Application No: BN/10/21/HH
Site Address: 2 Park Cottages Goodacres Barnham PO22 0JE
Description of works: Loft conversion consisting of hip-to-gable roof extension and rear box dormer with roof windows to front elevation.

Thank you for your internet representation made on 15th March 2021 which has been recorded as an objection with the comments as follows:

Drawing
Proposed Elevations

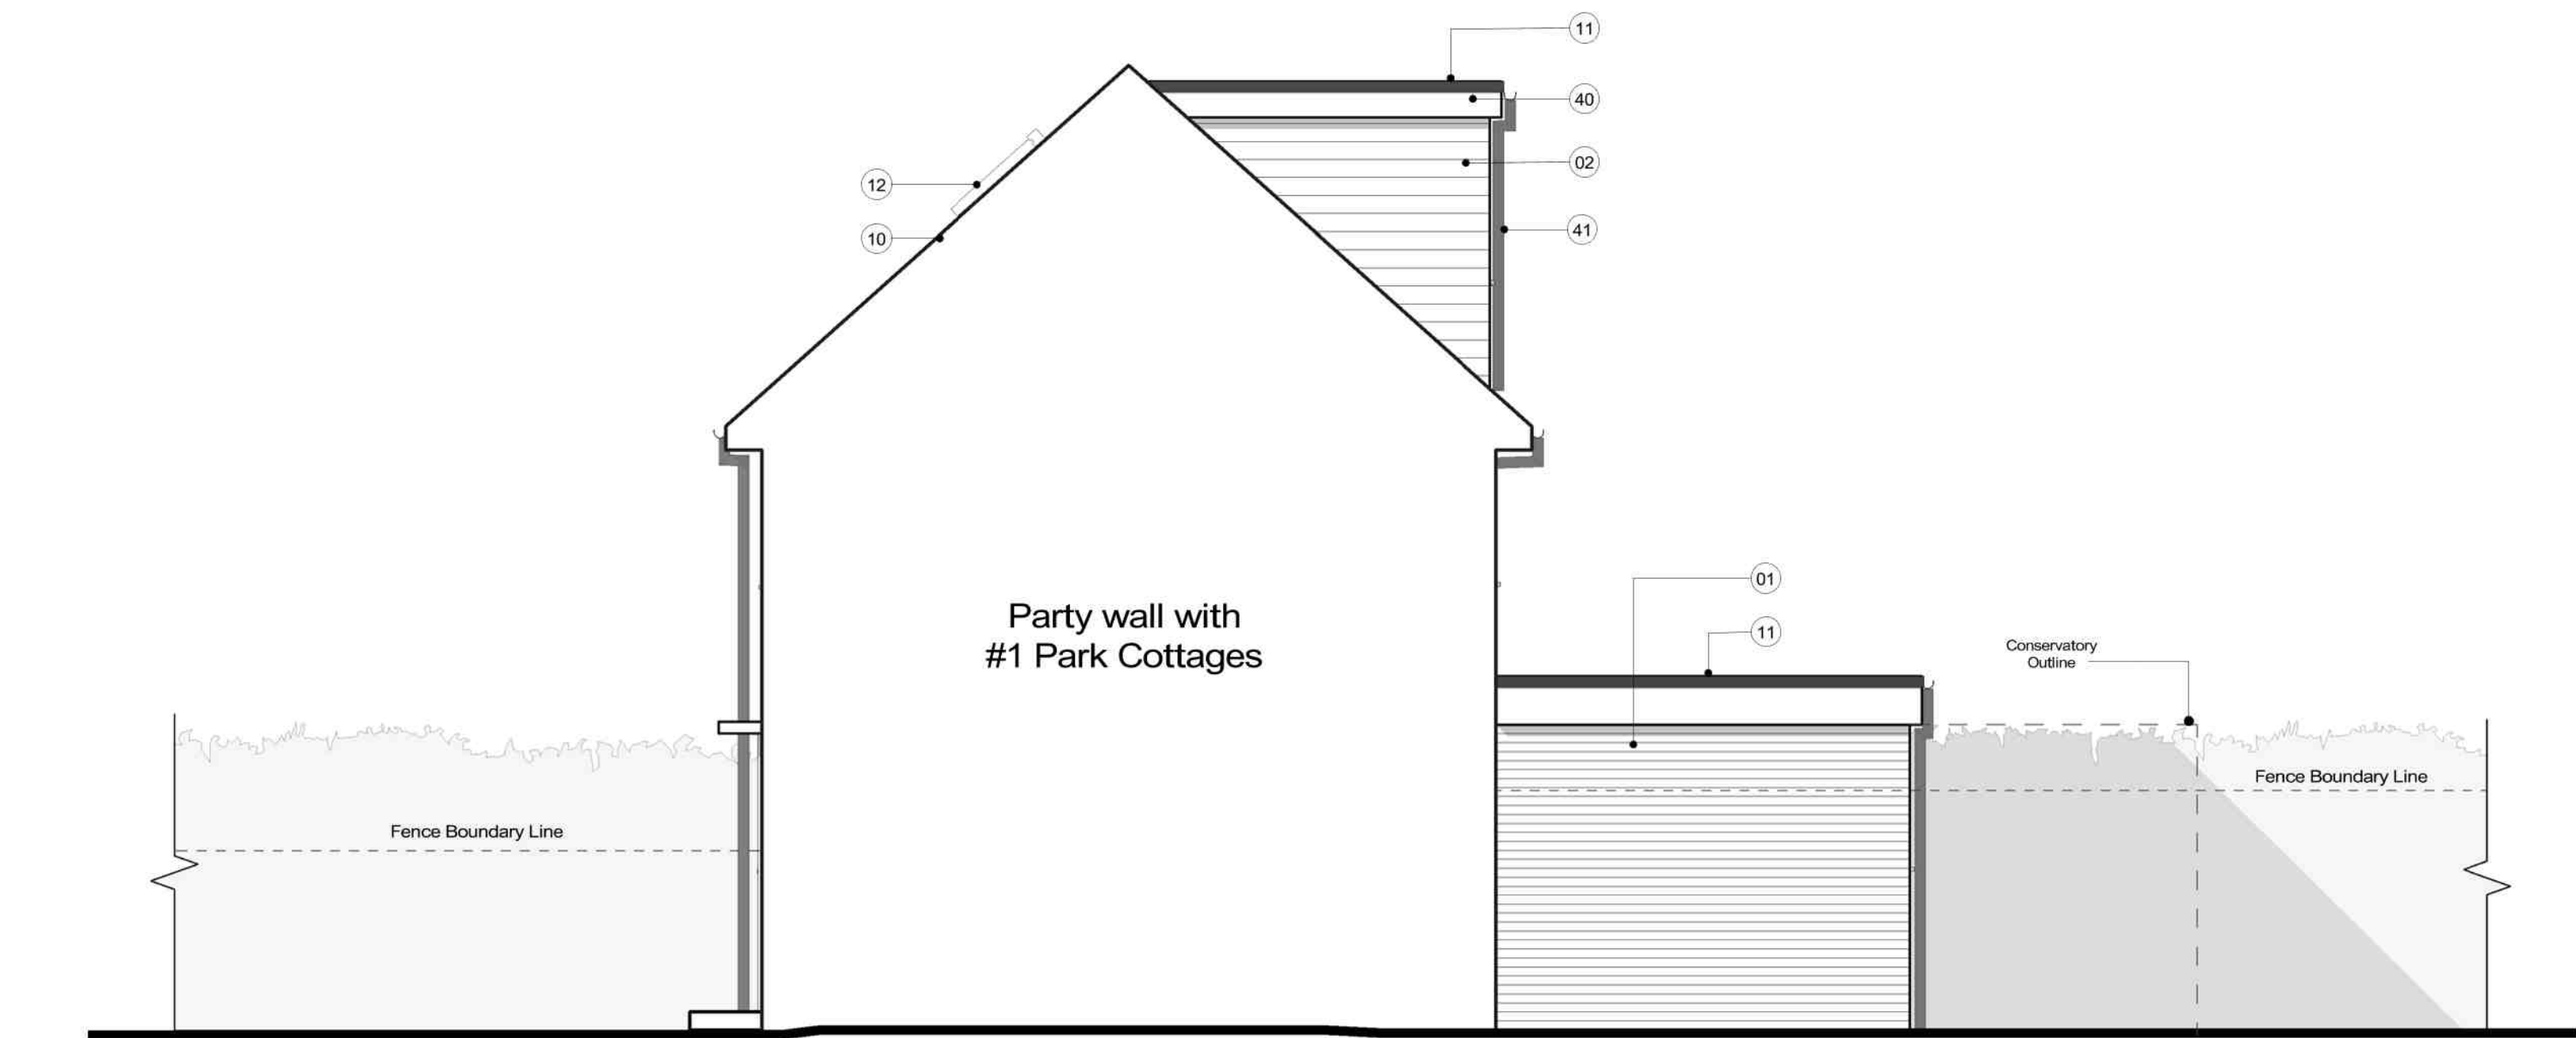
1. The extension is much too large would will be an eyesore.
2. If this extension is built there will be a lack of privacy in many neighbouring gardens.
3. This is not in keeping with all the other houses/bungalows in Goodacres.
